From: Holt, Kelly <Kelly.Holt@lancashire.gov.uk>
Sent: 07 August 2018 16:07
To: planning
Subject: D3.18.0638 - Hayfield, Main Street, Grindleton

D3.18.0638 – Hayfield, Main Street, Grindleton

Demolition of existing garage and replacement with new double garage and utility room/store with annex above. New two storey extension to rear including balcony with zinc cladding. Enlargement of existing dormers to front including zinc cladding and new roof material. New porch to front. New pergola to adjoin existing decking

PROPOSED GROUND FLOOR PLAN
Scale 1:50

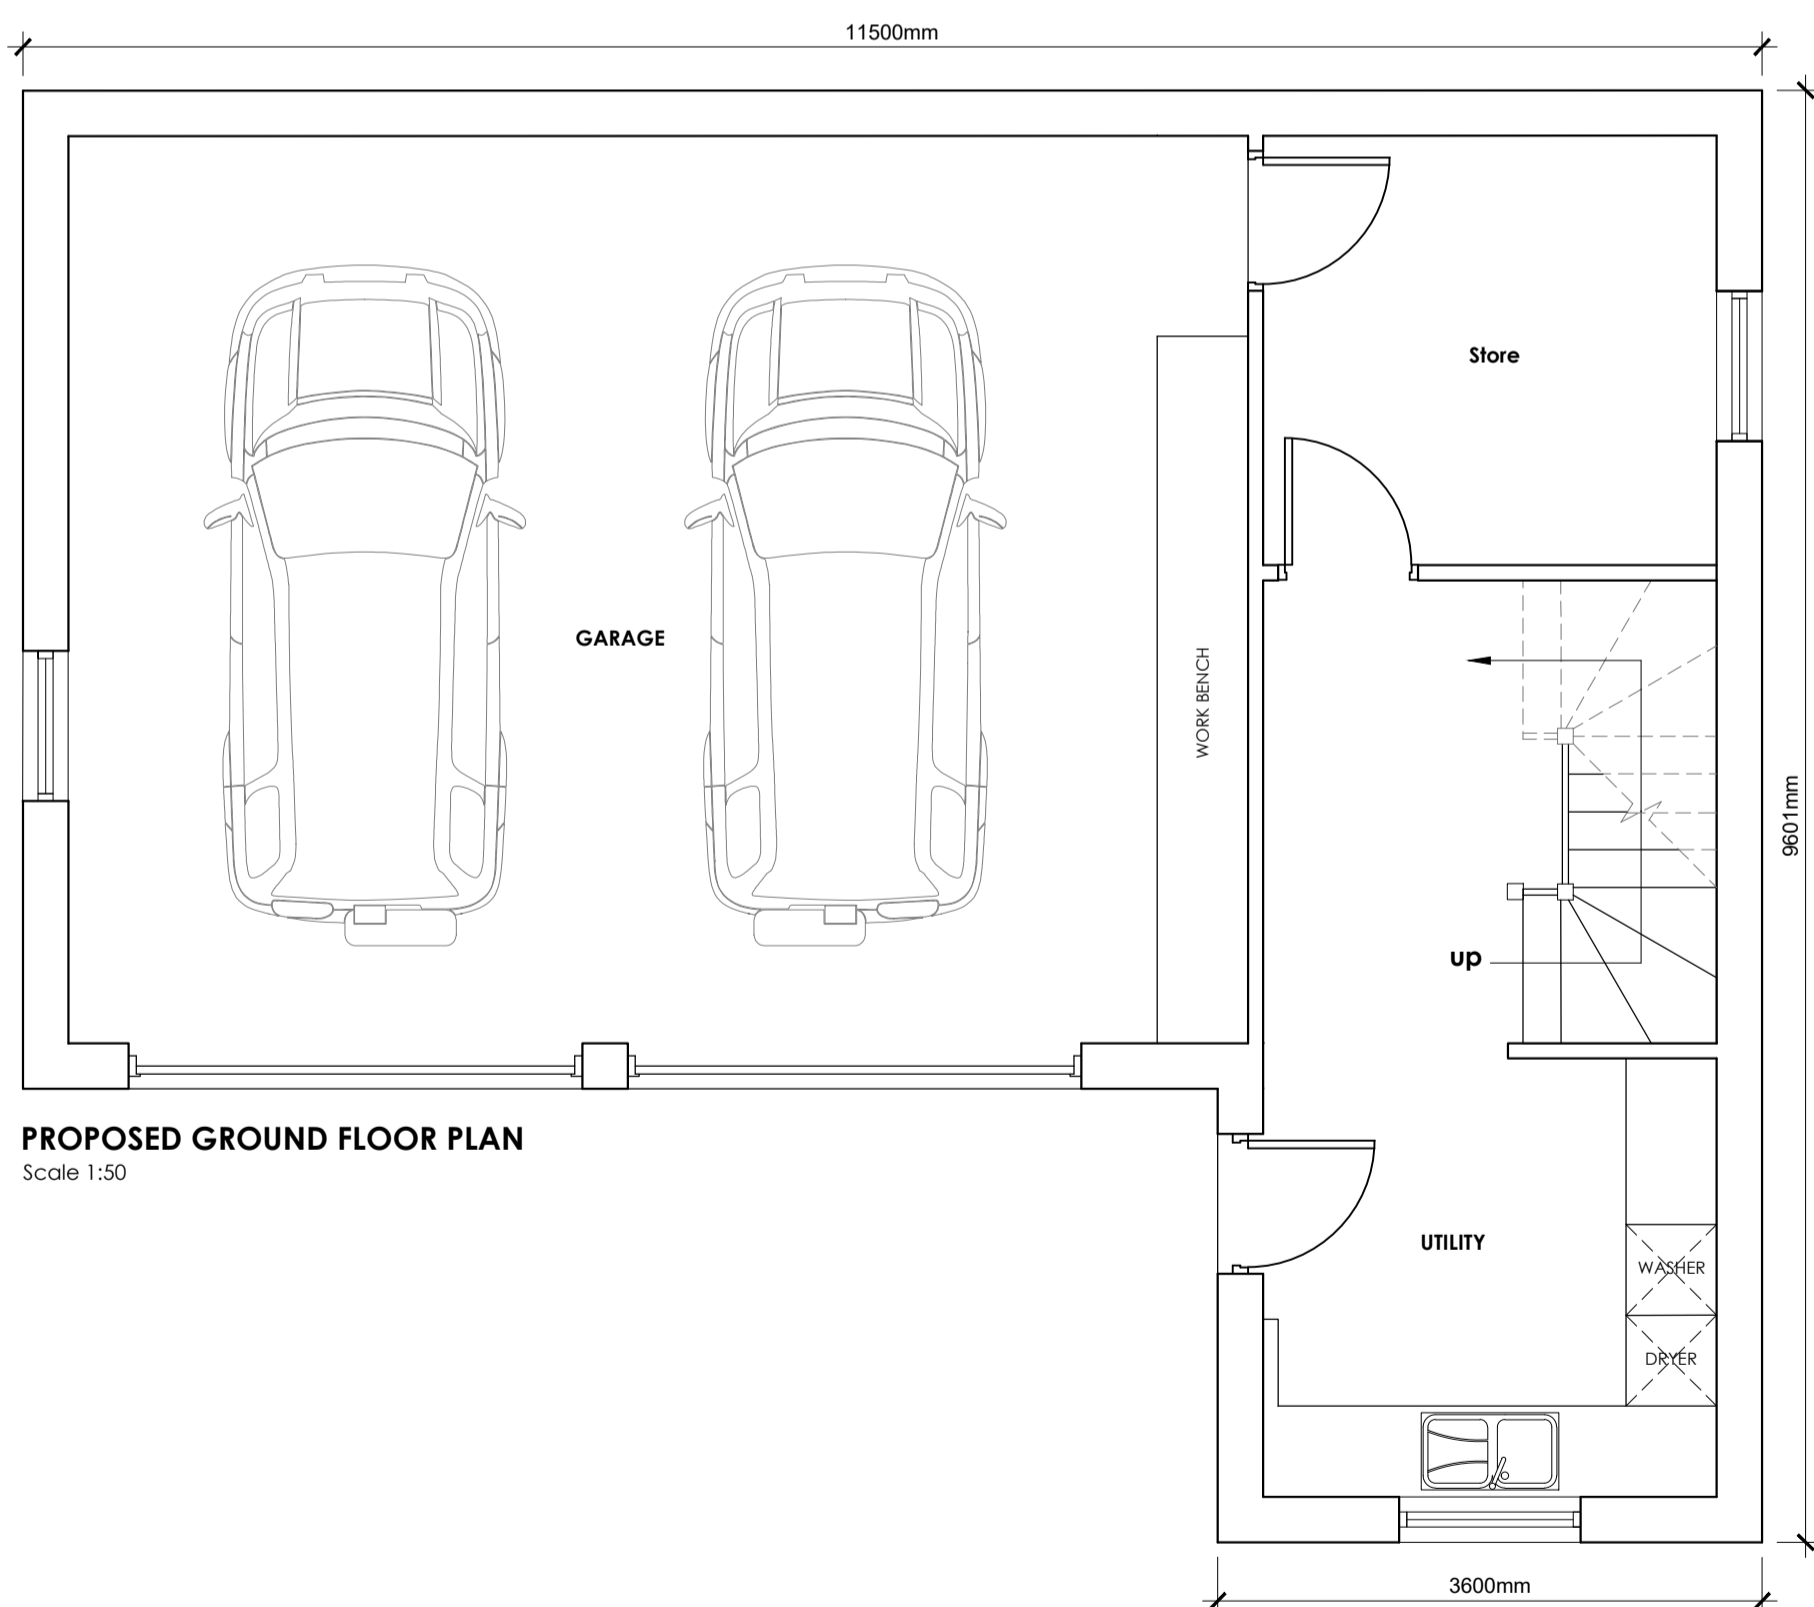
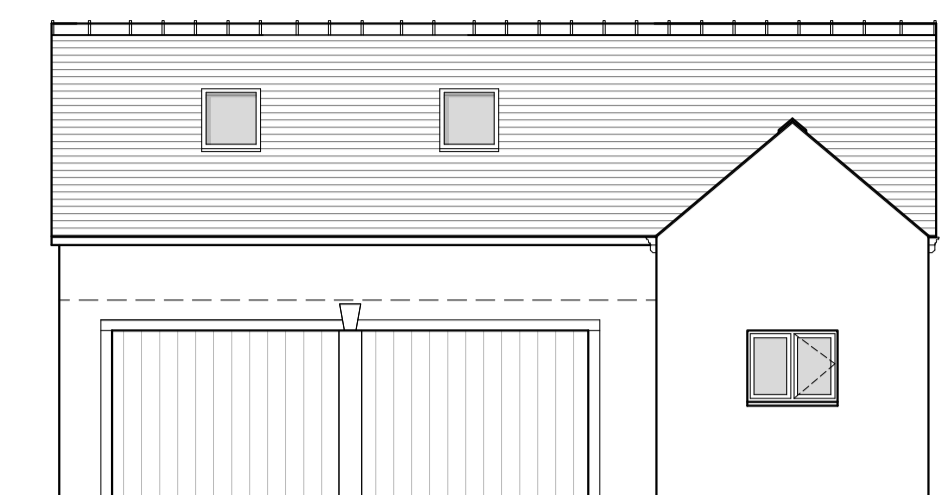
The proposed double garage measures 6m x 7.8m internally which provides parking for 2 vehicles and a number of cycles.

It is recommended that any rights are removed that would allow the garage to be converted to a habitable room without first obtaining planning permission. The reason for this is to protect the vehicle and cycle parking provision.

PROPOSED SITE PLAN
Scale 1:100

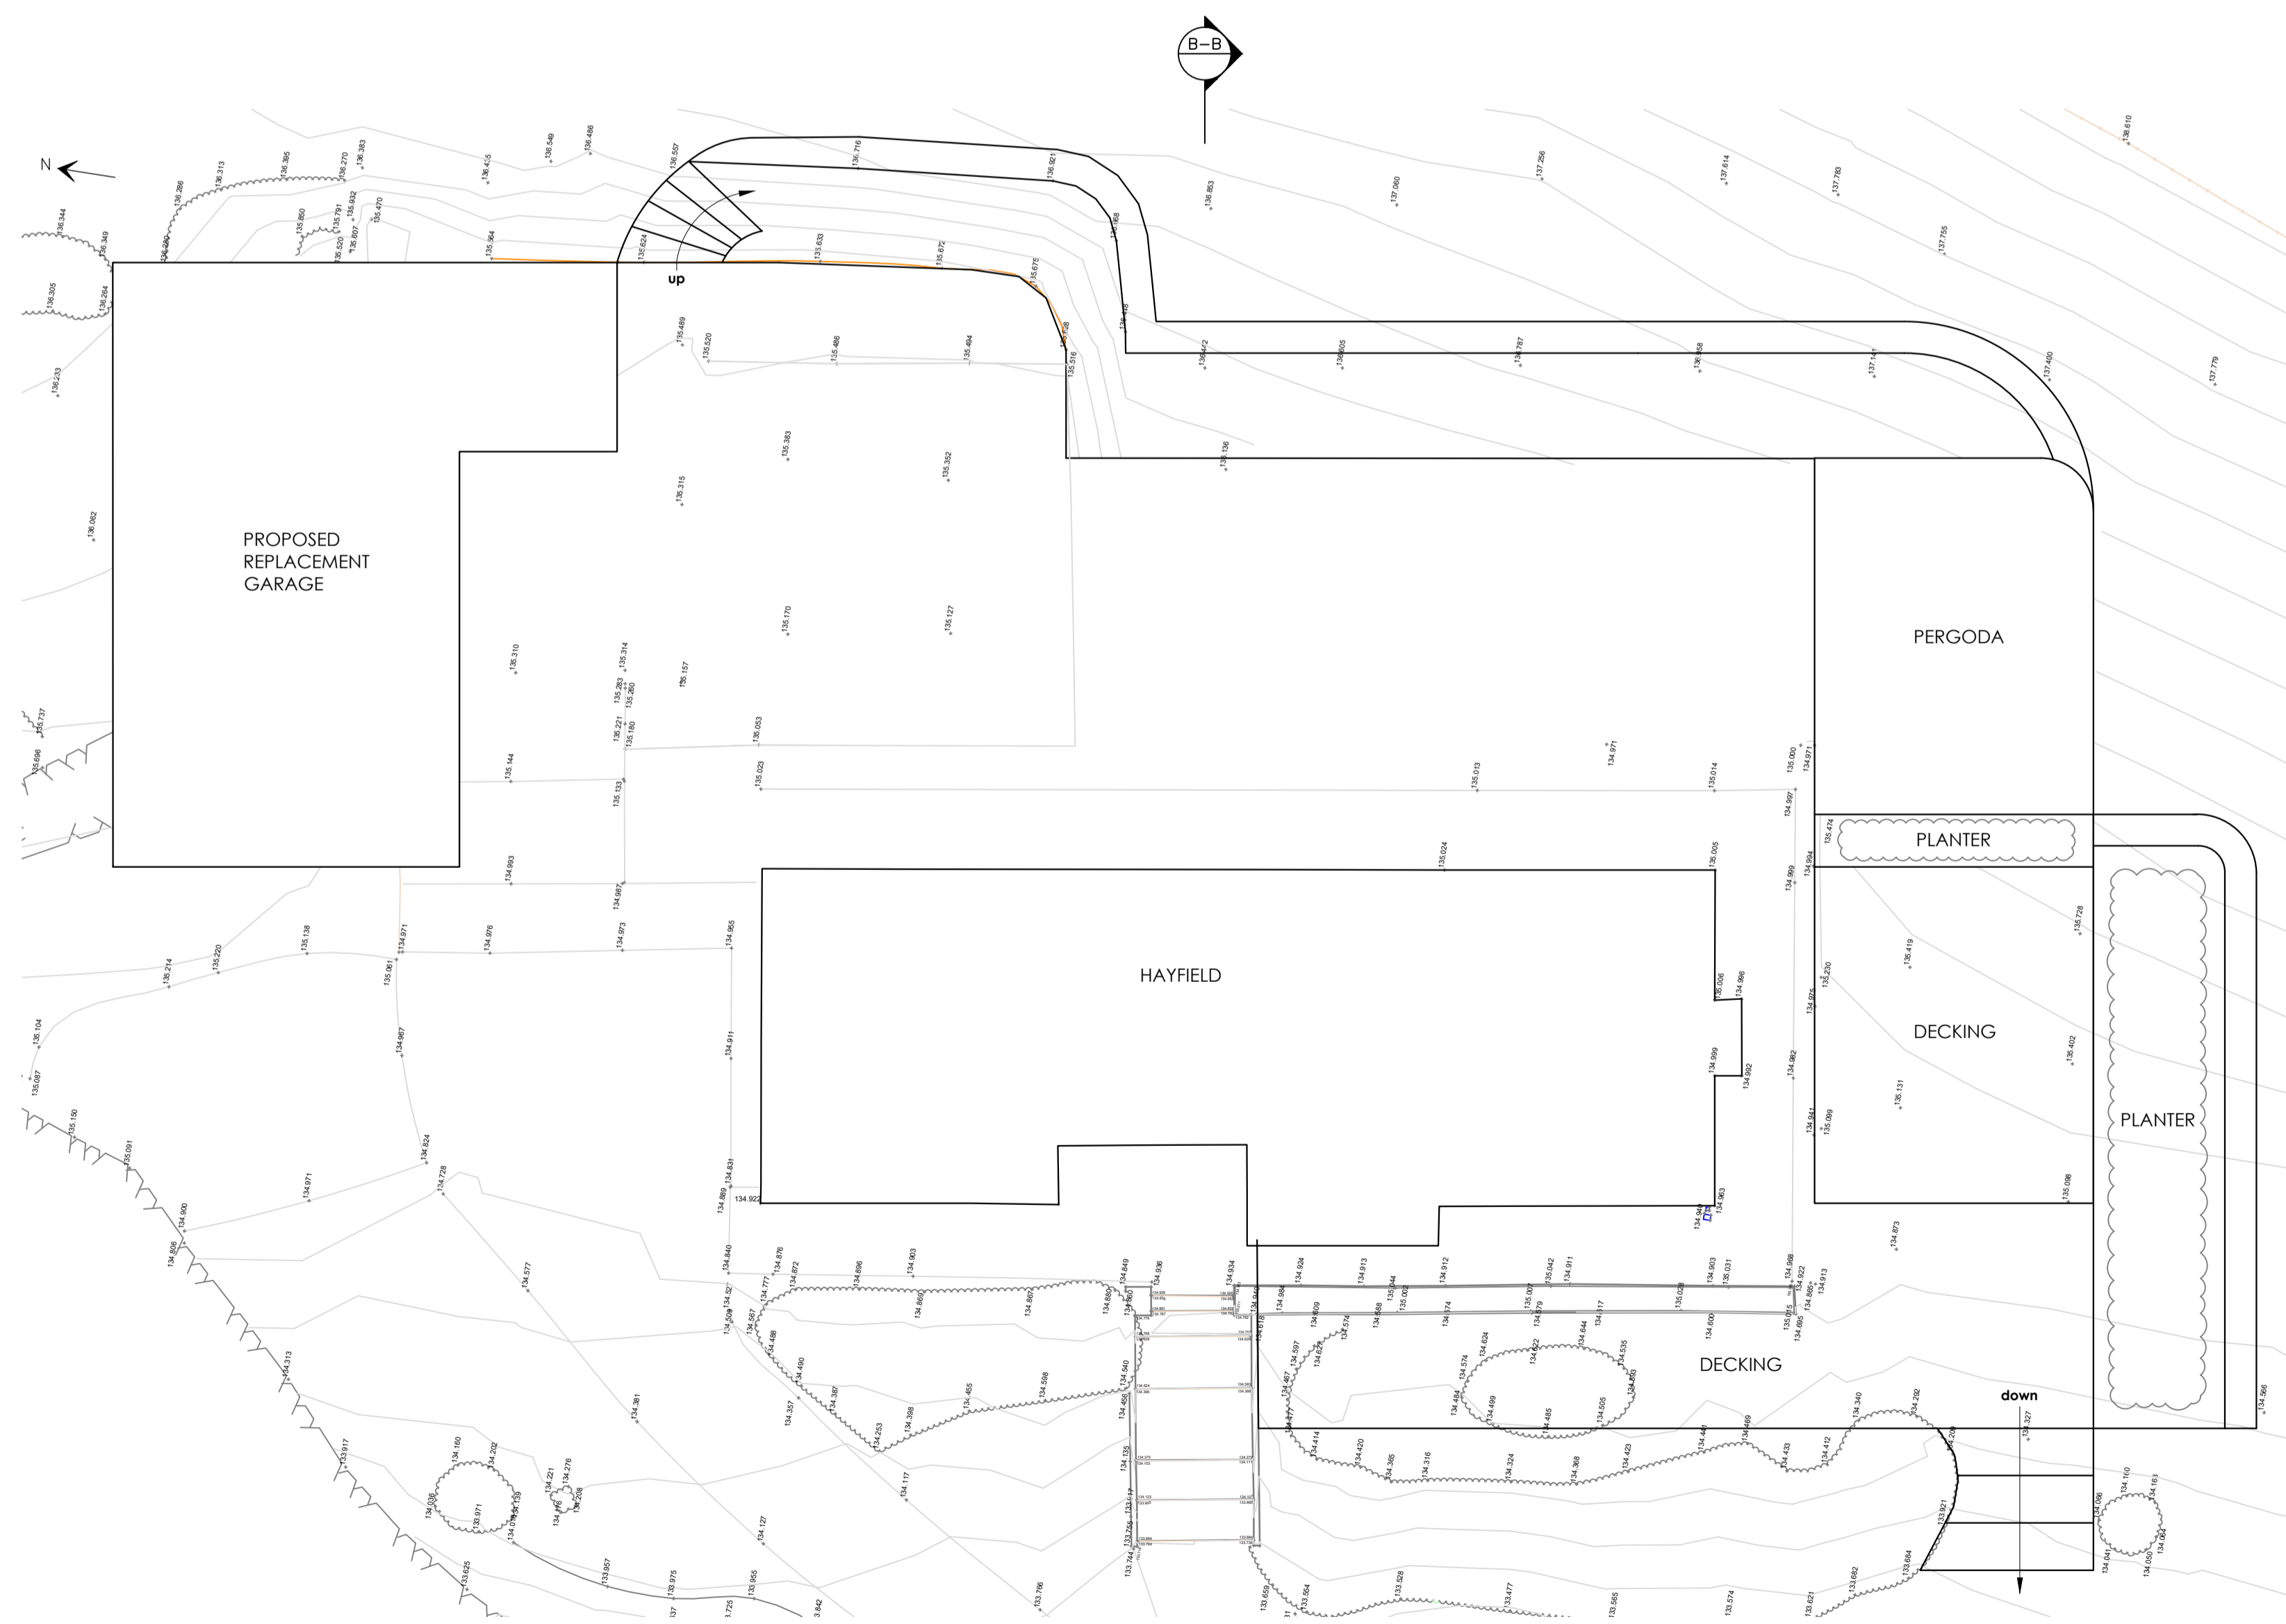
The main house and the proposed 1 bedroom annex require 4 parking spaces and space to turn and exit onto Main Street in forward gear.

There is no specific parking layout plan submitted however there appears to be ample space on the driveway and within the proposed double garage to provide sufficient parking and turning space.

There are no changes proposed to the existing access on Main Street.
